Arun District Council
Arun Civic Centre
Maltravers Road
Littlehampton
West Sussex BN17 5LF
Planning & Building Control General Enquiries
Tel: (01903) 737756 Fax: (01903) 730442
Dx: 57406 Littlehampton
Minicom: 01903 732765
e-mail: planning@arun.gov.uk
website: www.arun.gov.uk/planning

Application No: Y/152/20/RES
Site Address: Land at Bilsham Road Yapton
Description of works: Approval of reserved matters (appearance, landscaping, layout and scale) following the grant of Y/91/17/OUT for 250 No. dwellings with associated parking, road/footway/ cycleway provision, open space, landscaping, surface water attenuation & ancillary works.

Thank you for your internet representation made on 18th February 2021 which has been recorded as an objection with the comments as follows:

Front Elevation
Plots : 16/17,

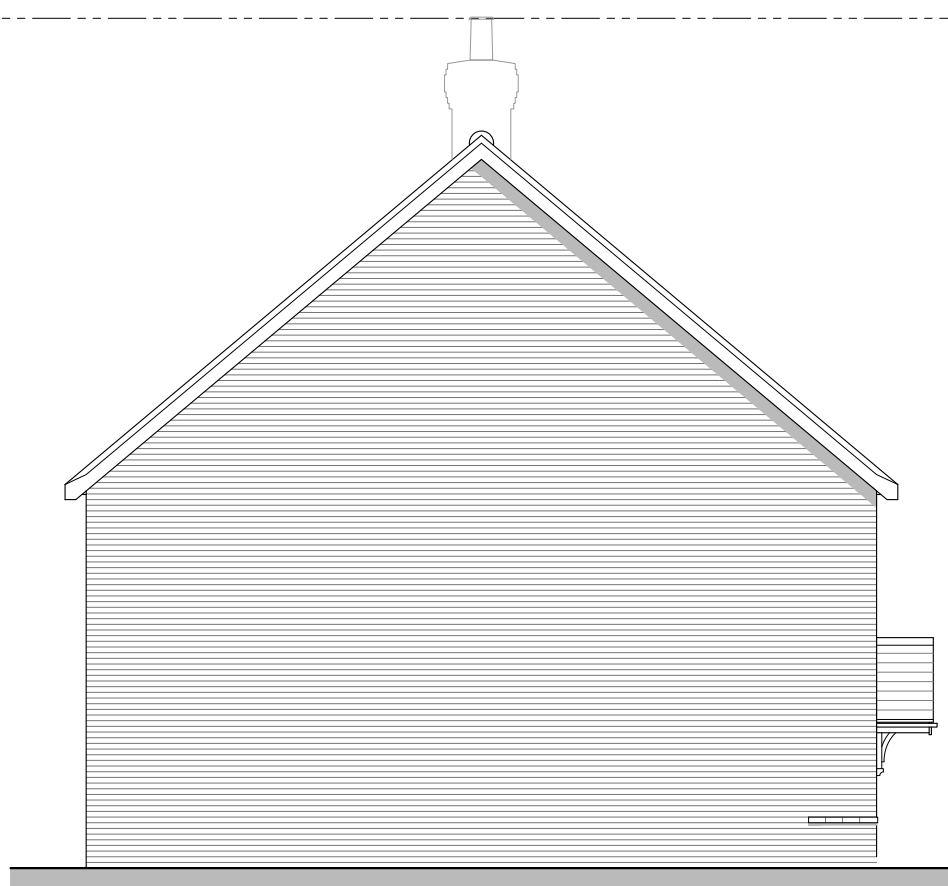
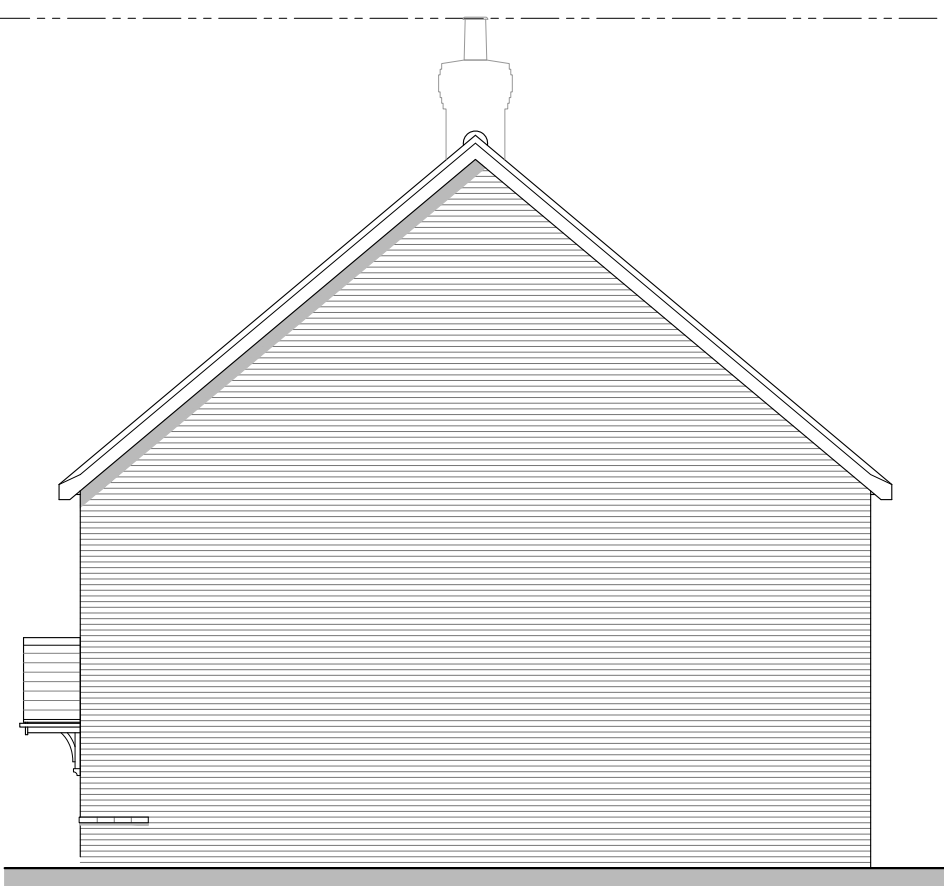
Having reviewed to plans for the development we believe they do not properly represent the extension to our property completed in 2018 and therefore the application to building standards to the development do not provide us with the protection of our rights to light and privacy we believe we are entitled to.

Principally our master bedroom picture window on the side elevation facing the development is within a few metres of the house on plot 16 and the master bedroom bi-fold doors on the rear elevation are within the 23 metres we believed to be our entitlement at the time of planning our extension.
